Ku-ring-gai Council Submission

Major Project MP08_0244 –Environmental Assessment –
Mixed Use Development - 23-37 Lindfield Avenue and 11 Havilah
Avenue, Lindfield

December 2010

4 CONCEPT FUTURE EXTENSION- BASEMENT  
1:200

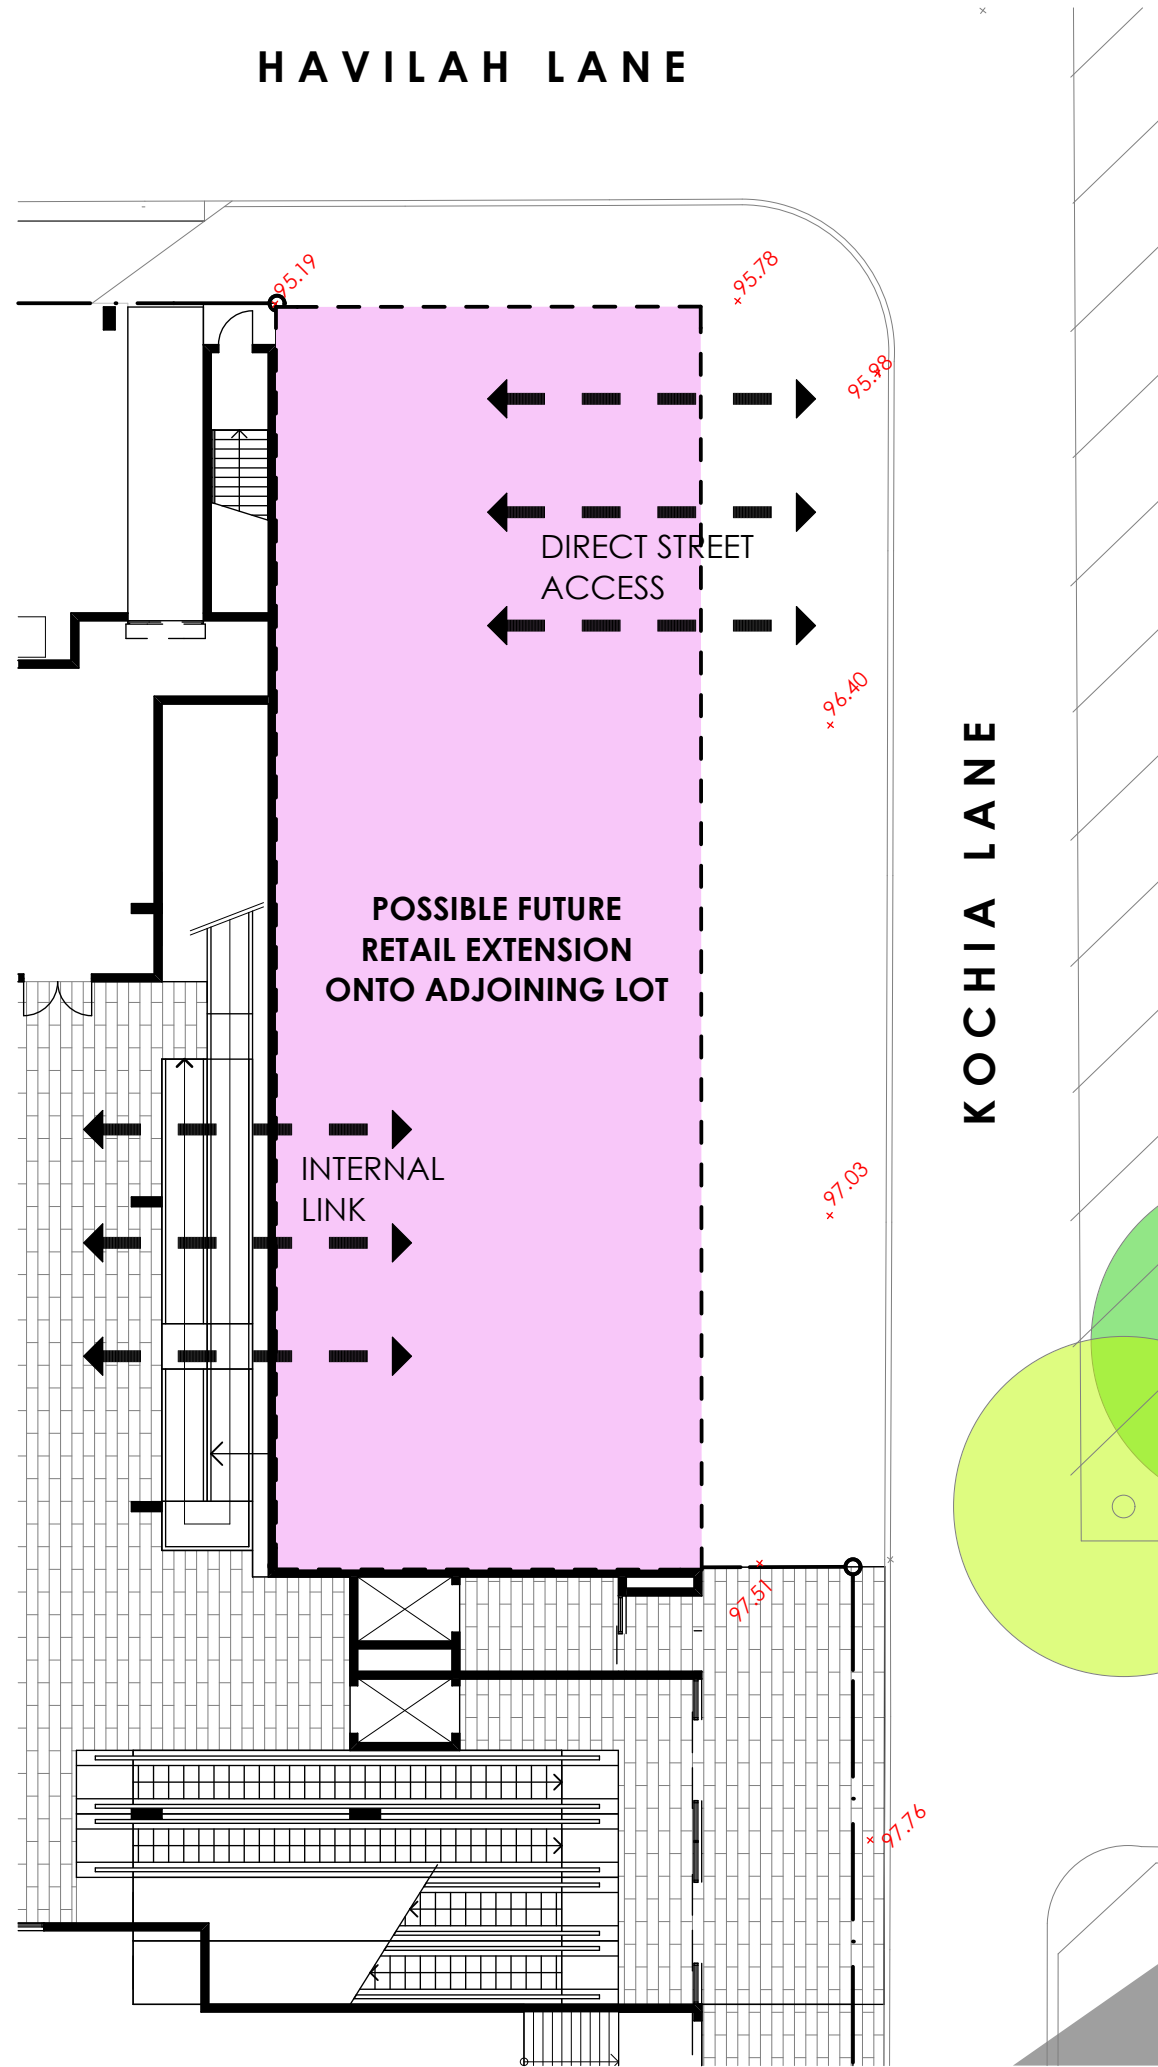
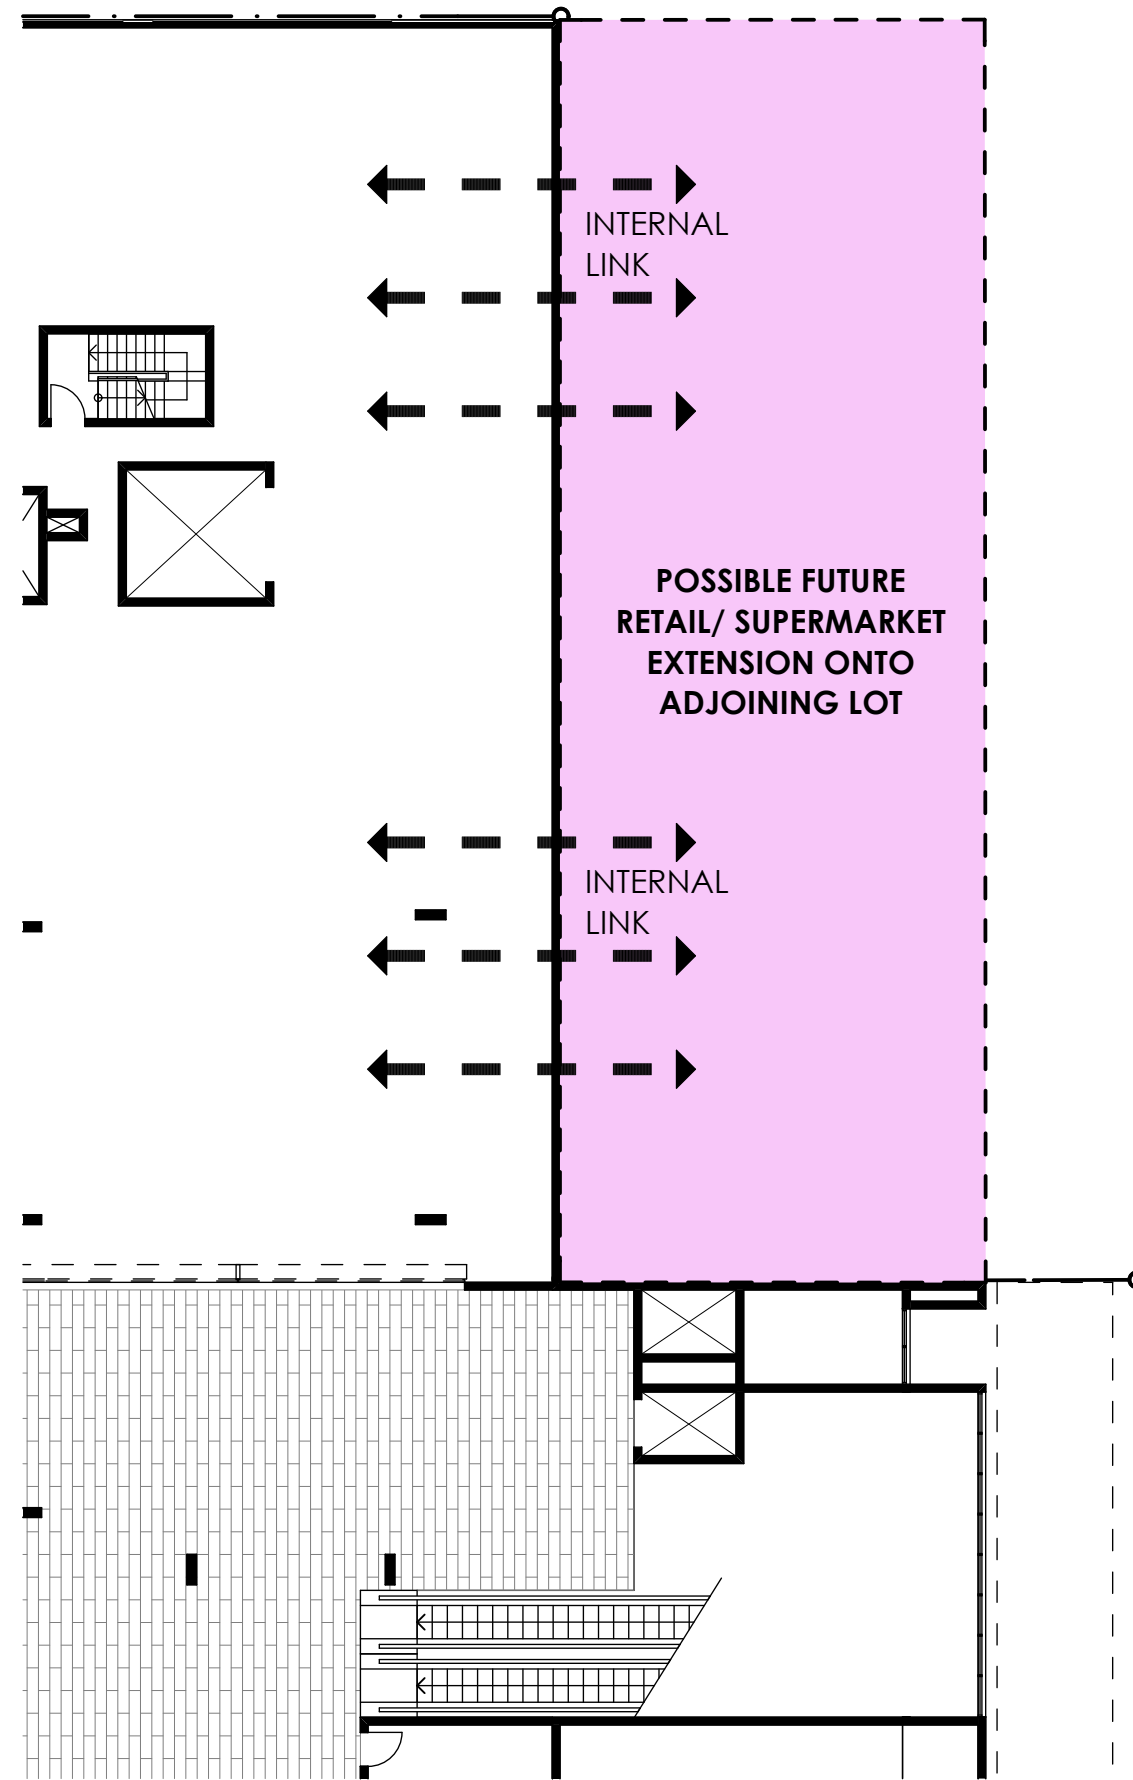
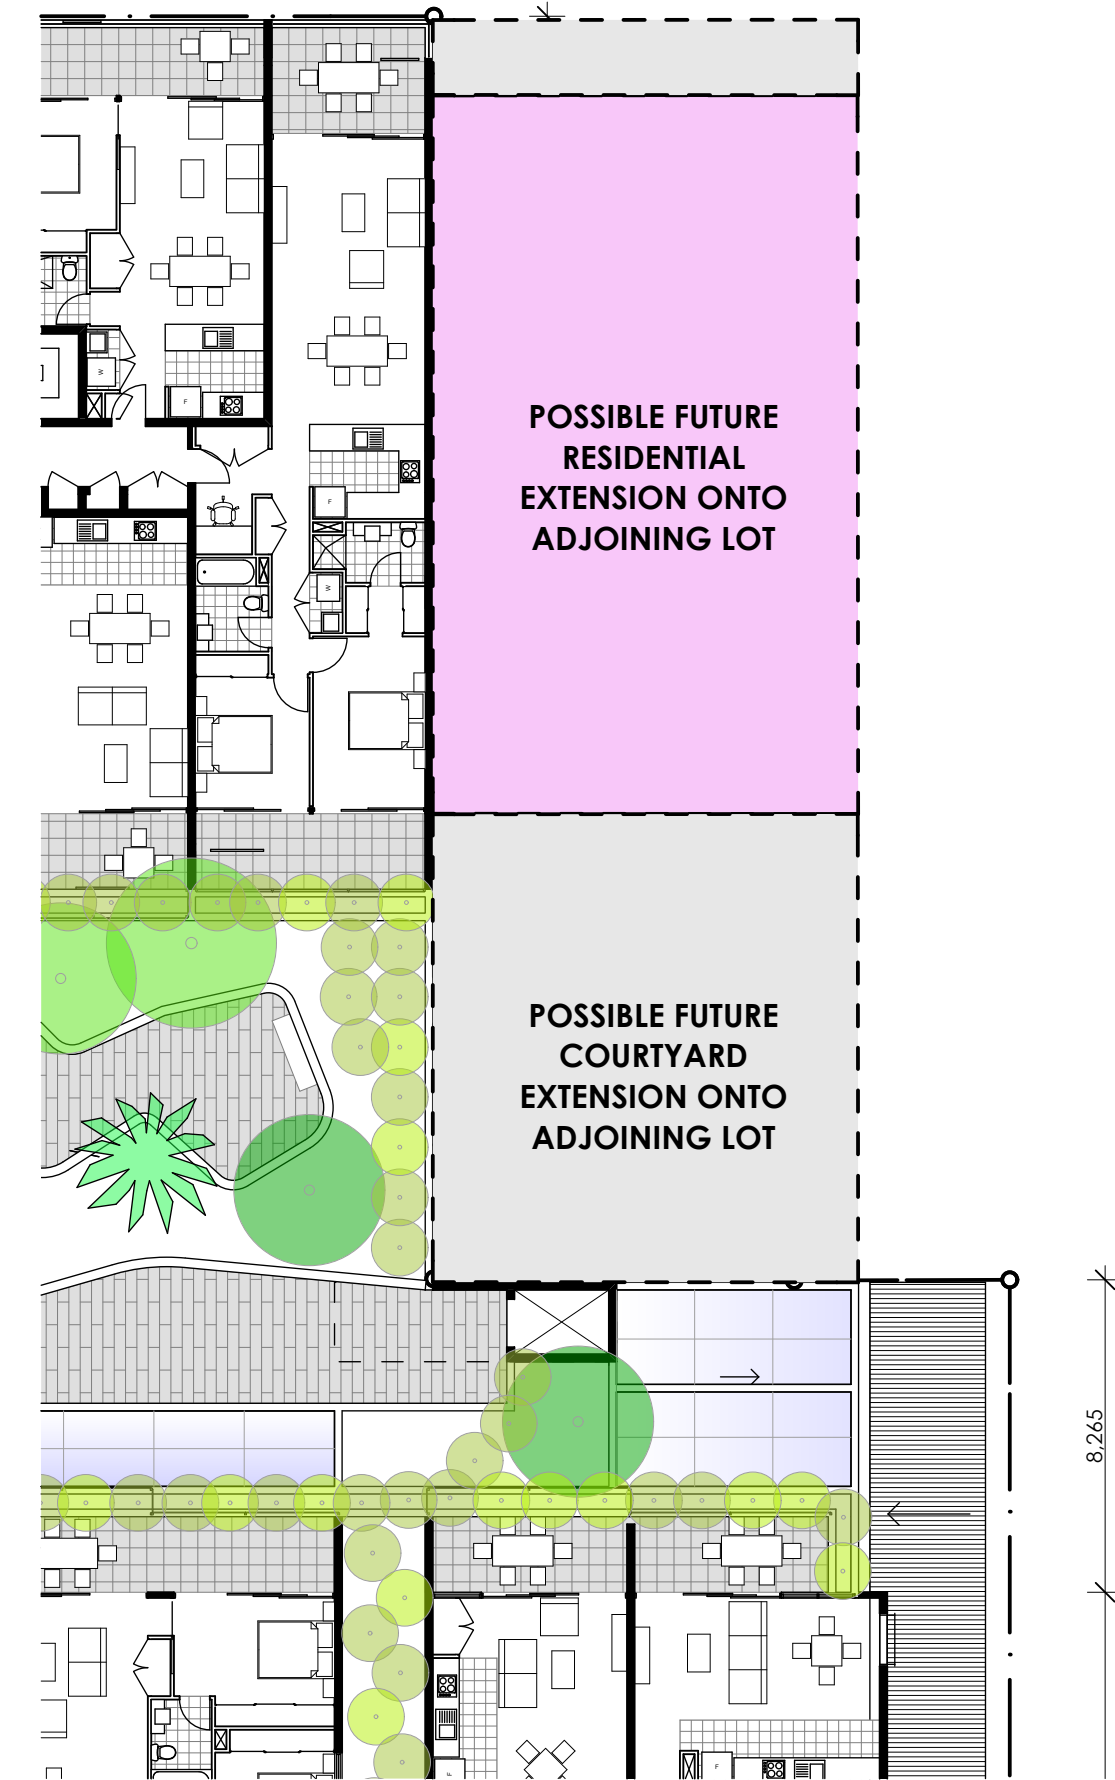
The Department has strongly emphasised the need for the proponent to address the issues and implications of not incorporating the land at No.2 Kochia Lane into the amalgamated site. The EA fails to provide details of steps taken to incorporate the site at No.2 Kochia Lane, either through purchase or joint venture, or to demonstrate that this site can be redeveloped as an economically viable stand alone development in the future.

The EA has given a basic consideration to this matter and has not properly demonstrate that the independent development of 2 Kochia Lane can achieve the desired outcomes sought under the town centres LEP and DCP for this important site, including:

- Reasonable retail and residential yields;
- The provision of increased setbacks to Kochia Lane and Havilah Lane to provide pedestrian amenity (and potentially the widening of Kochia Lane);
- Adequate basement parking. Note that Council's ability to provide public parking to offset reduced parking on the site has been limited by the recent cap on Developer Contributions.
